**Consultation Response from KC,  
Highways Development Management**

**2024/90591 Land at, Lancaster Lane, Brockholes, Holmfirth, HD9 7BP**

**Discharge conditions 3 (internal estate roads) and 5 (future management and maintenance) on previous permission 2021/91578 (APP/Z4718/W/21/3284361) for erection of 9 detached dwellings with associated works**

**Date Responded: 14-5-2024.**

TITLE: **UNADOPTED ROAD DETAILS**

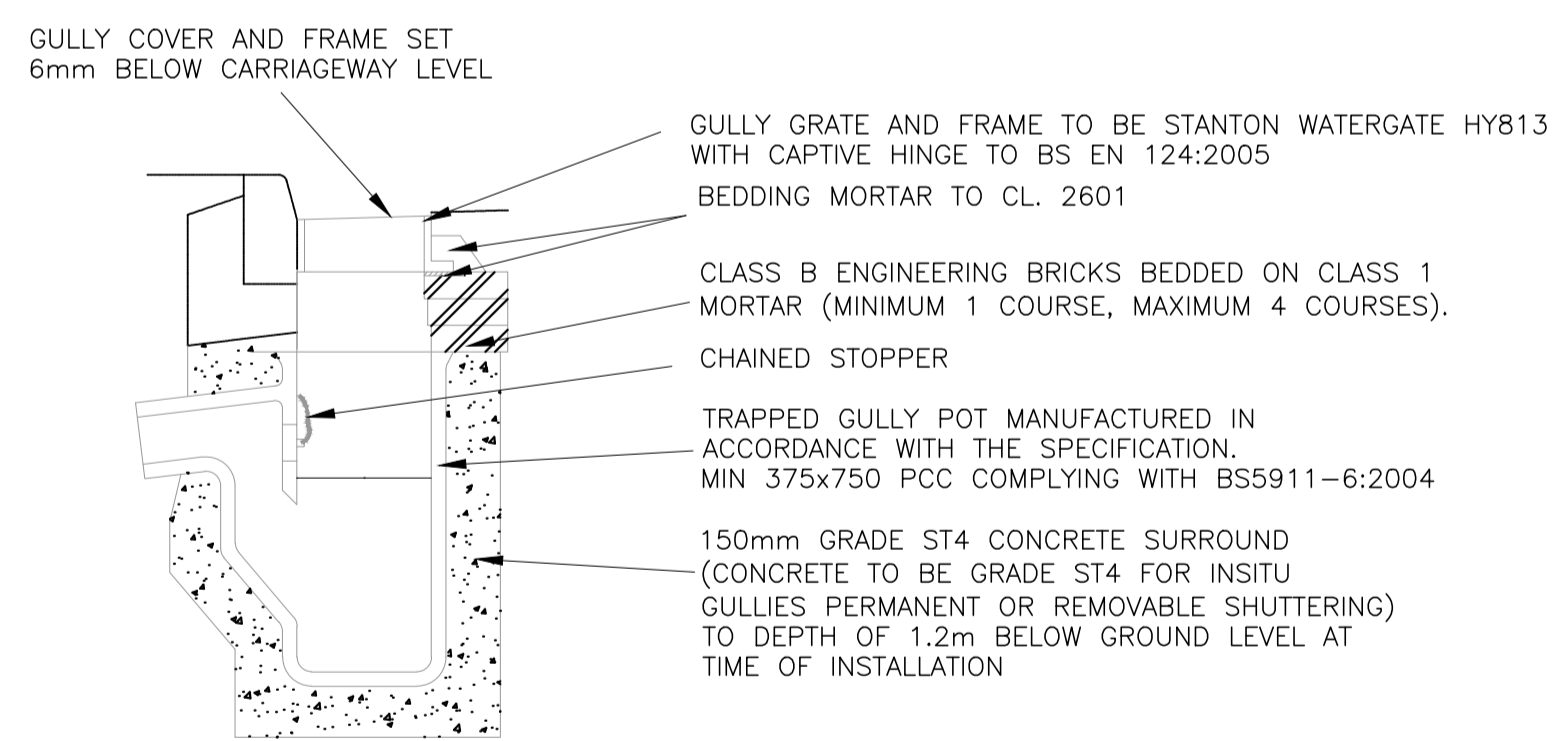
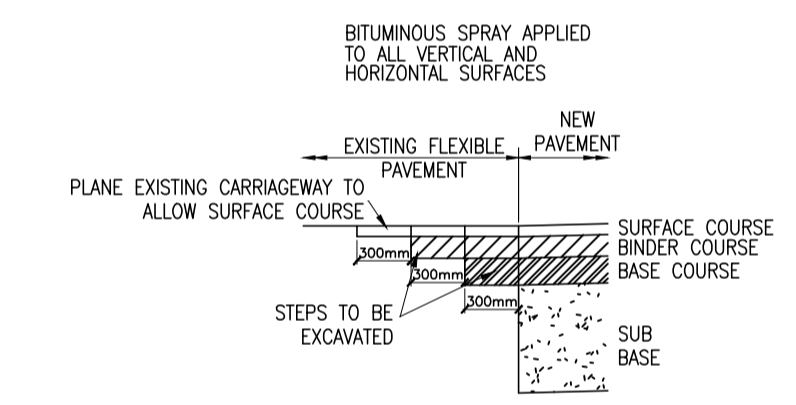
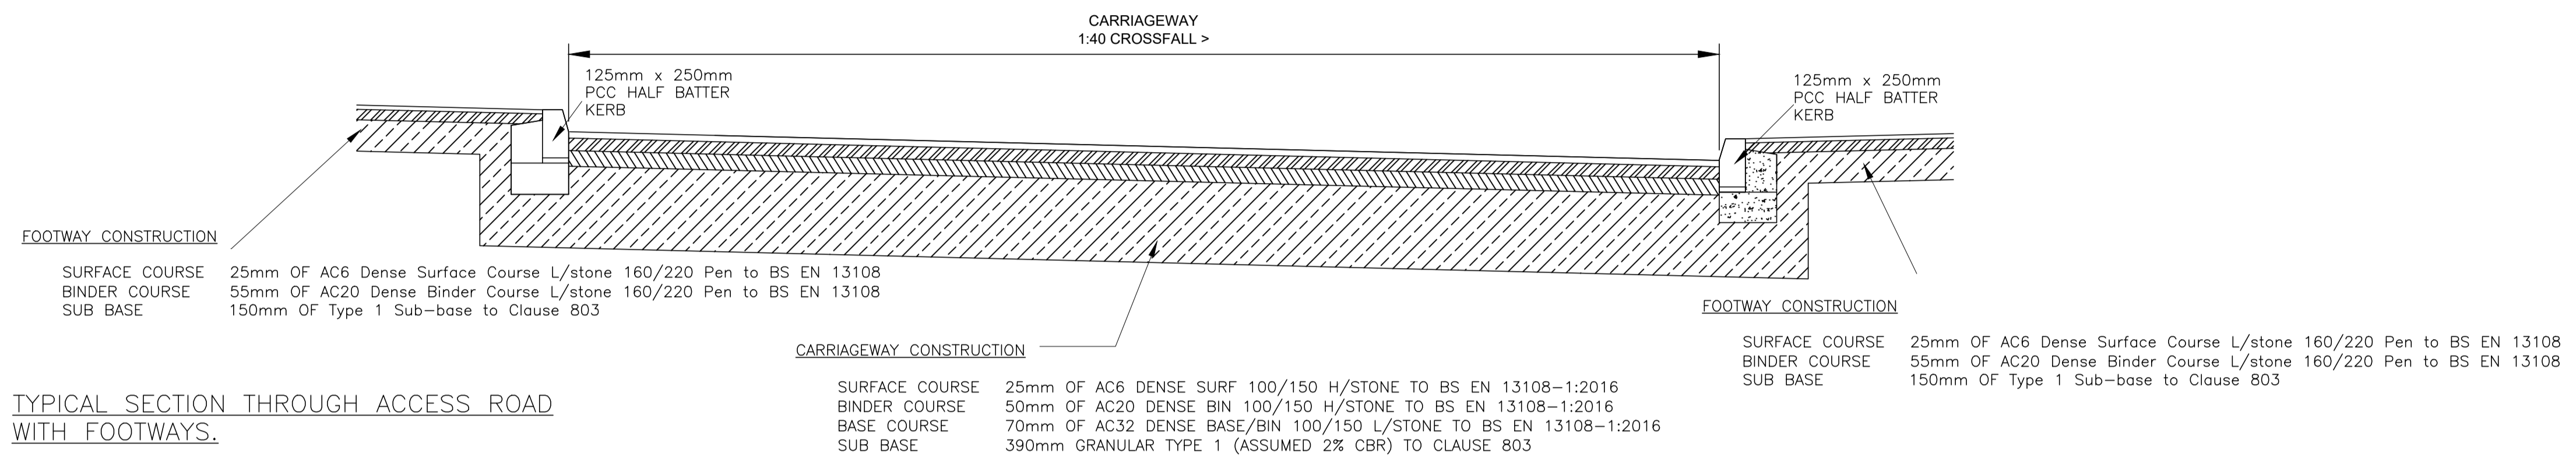
- 4, The plans attached to the Drainage Strategy document show drainage channels across the width of the carriageway at intervals. These are not acceptable for a road build to an adoptable standard. The drainage design should include road gullies only.
- 5, The unadopted road details do not show details of the blocked paved hard margins.

Client JAMES WOOD PETRIAN CONSTRUCTION	Drawing No TWP20-NTF-E02-005
Contract LAND OFF LANCASTER LANE BROCKHOLES HUDDERSFIELD	Revision A
Drawing PROPOSED RESIDENTIAL DEVELOPMENT LANCASTER LANE ACCESS DETAILS	Date Jan '24
	Scale 1:250-1:50-1:25 @ A1
	Drawn CAB
	Checked

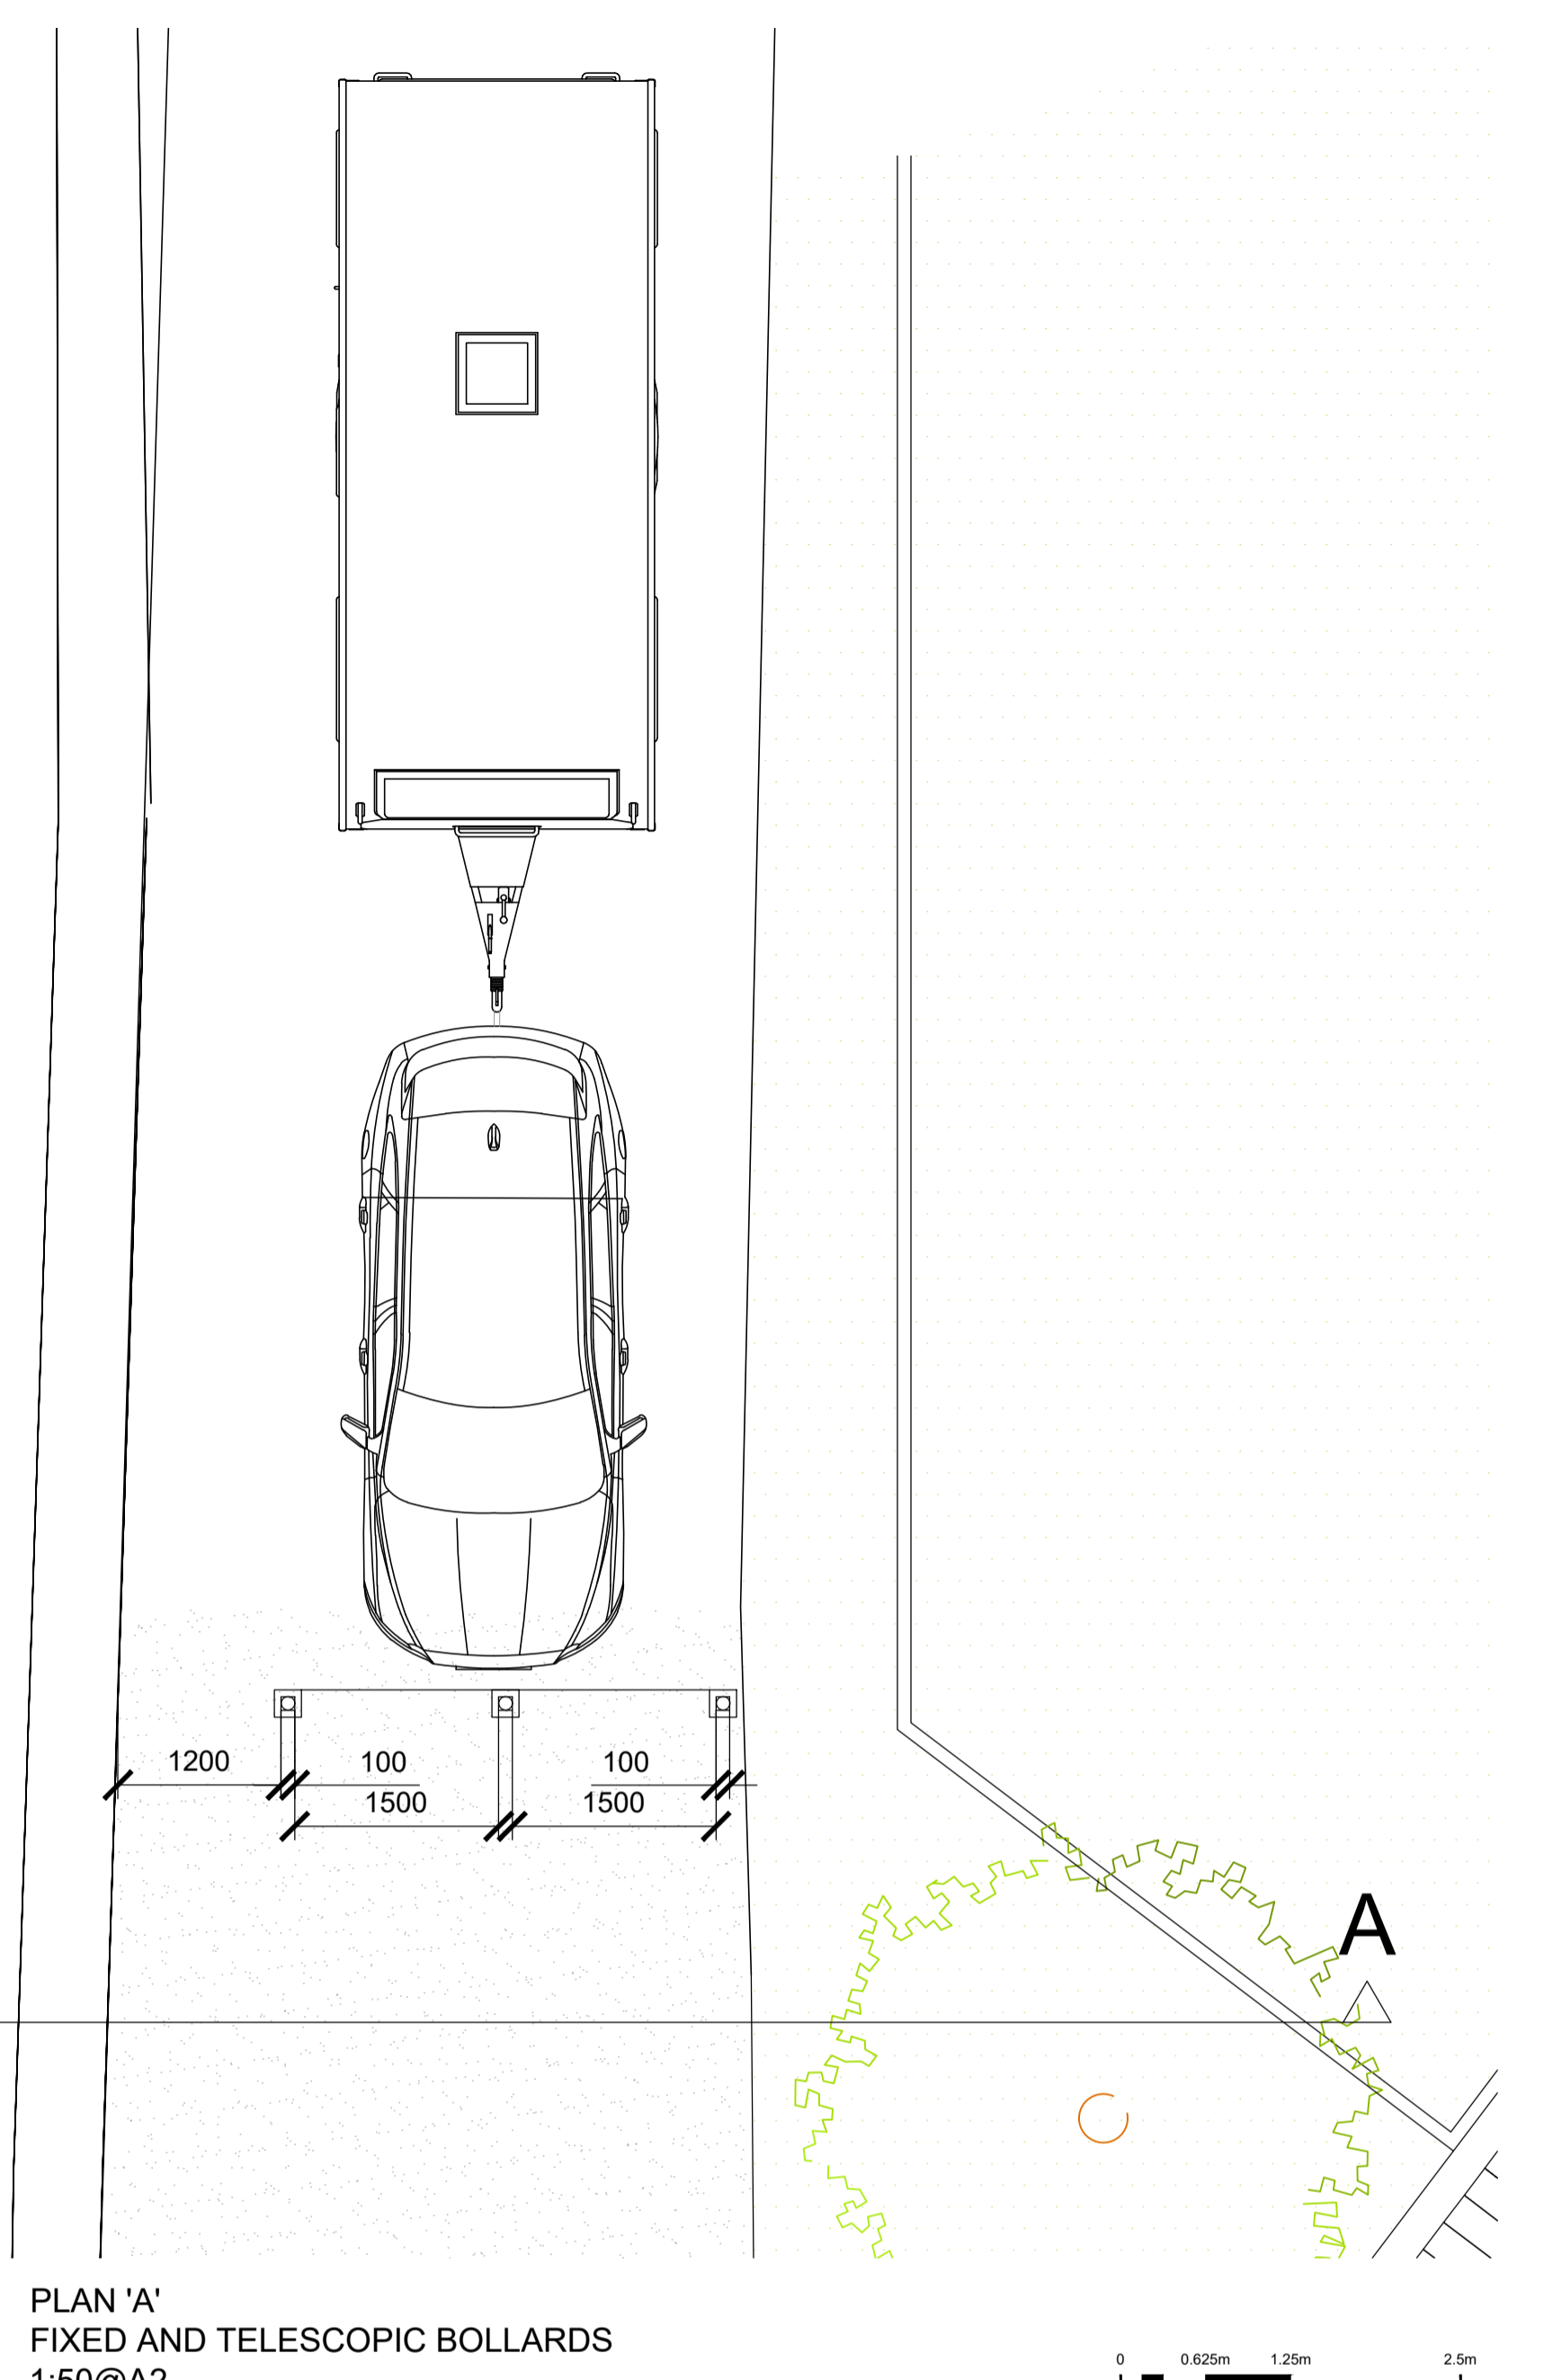
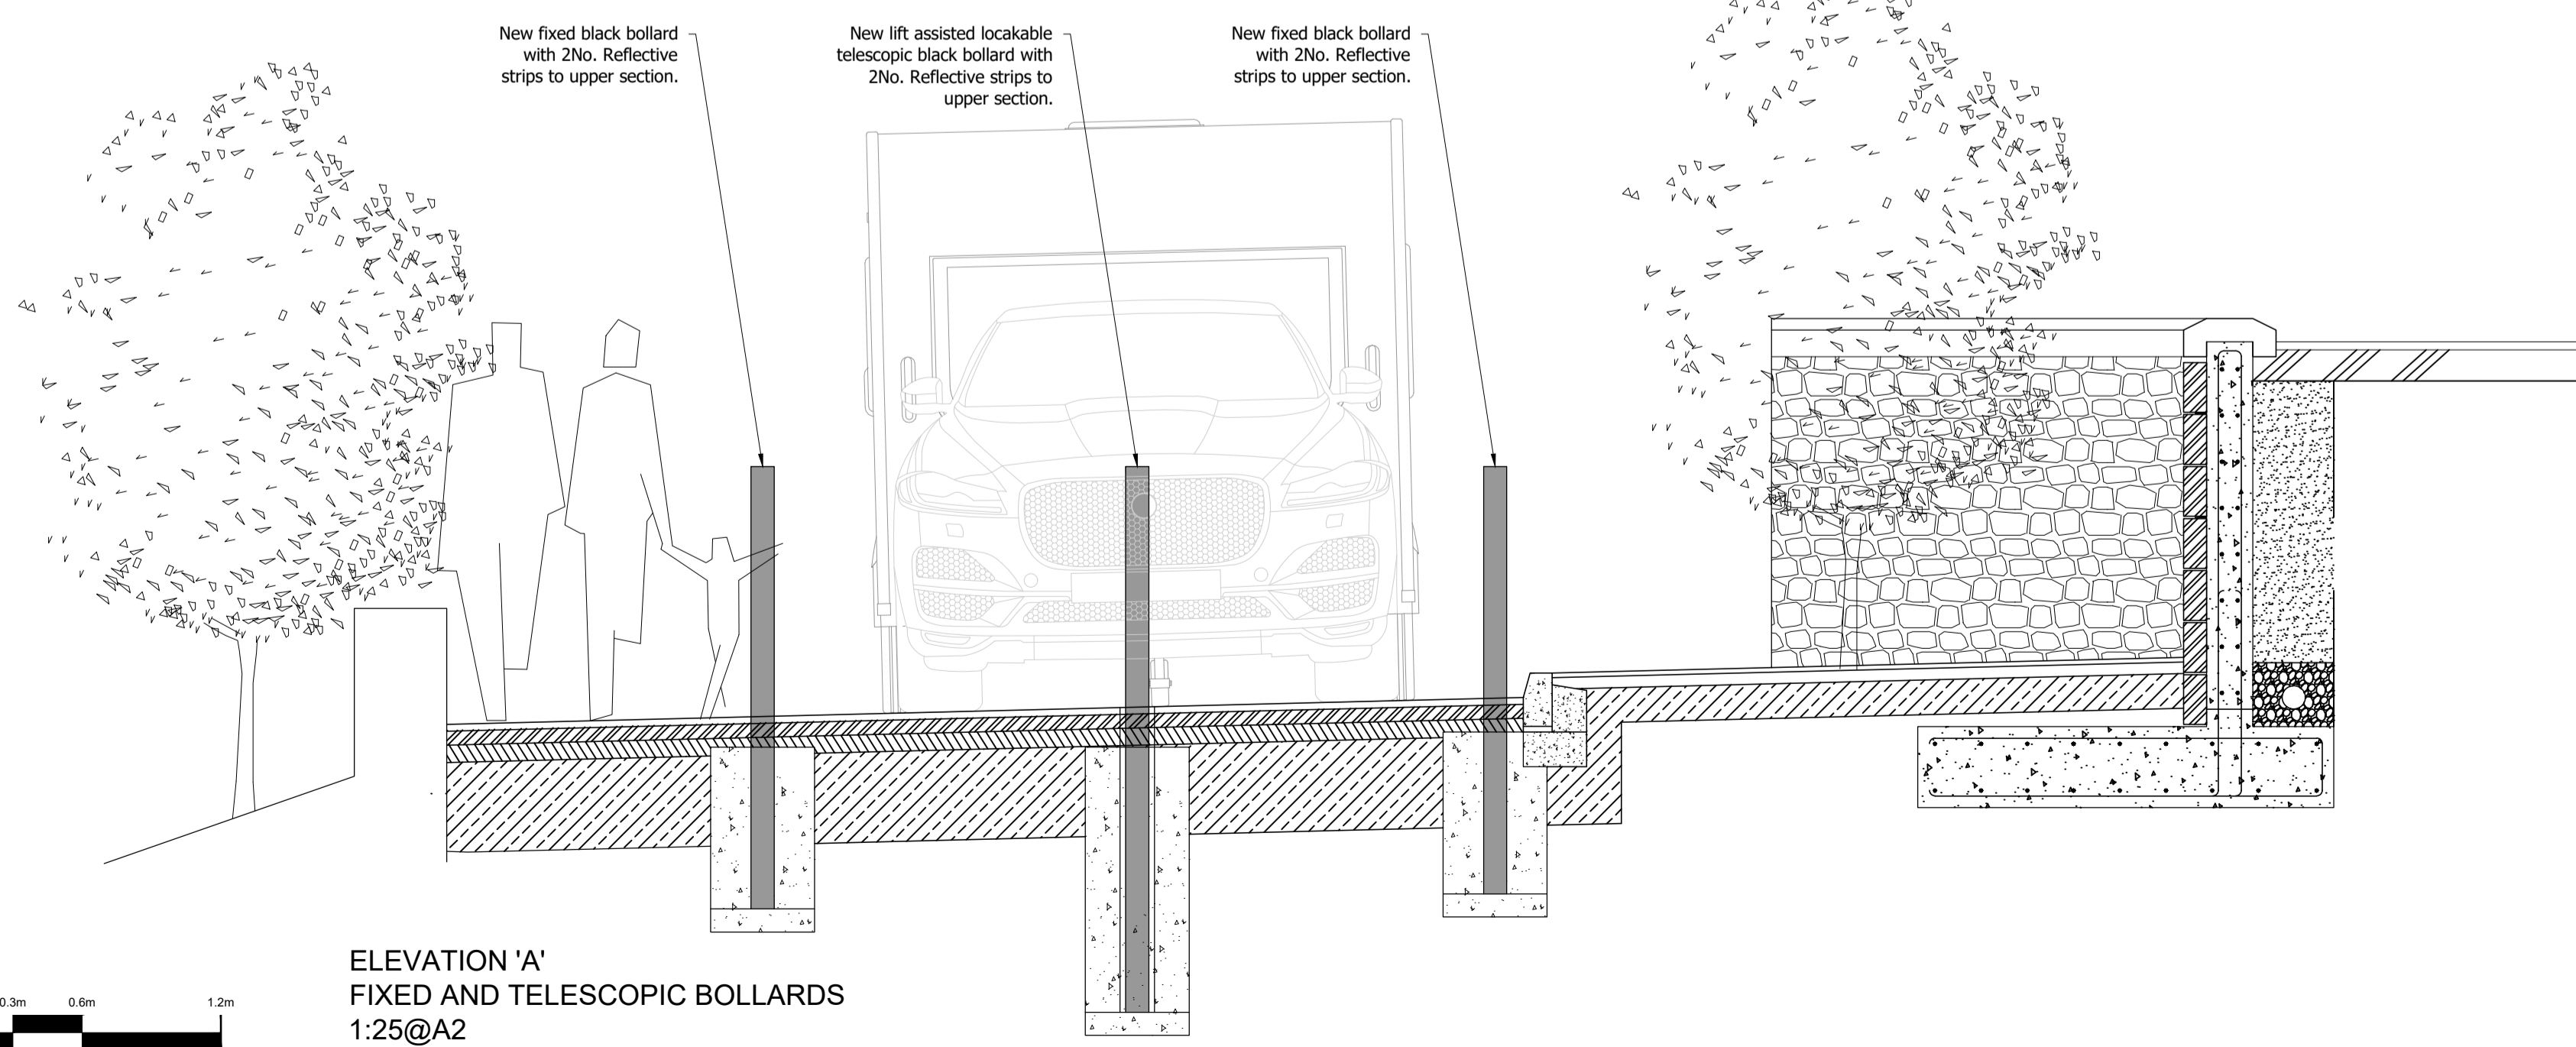
- 1, PROW have been consulted, and they confirm that this section of Lancaster Lane is used by houses and bike riders and should **not** be gated, lockable collapsable bollards should be used instead to allow a suitable access for horse and bike riders.
- 2, Highways Structures have been consulted and they have confirmed that the existing retaining wall to the western boundary of the site will not have been constructed to a standard that will allow highway loading and this wall will therefore need to be re-designed to be to a suitable standard.
- 3, The Drainage Strategy document shows a 5.0m x 3.0m x 1.0m attenuation tank within Lancaster Lane. Lancaster Lane is a PROW and shares the same status as an adopted highway and the proposed tank will therefore be liable to systematic inspection.
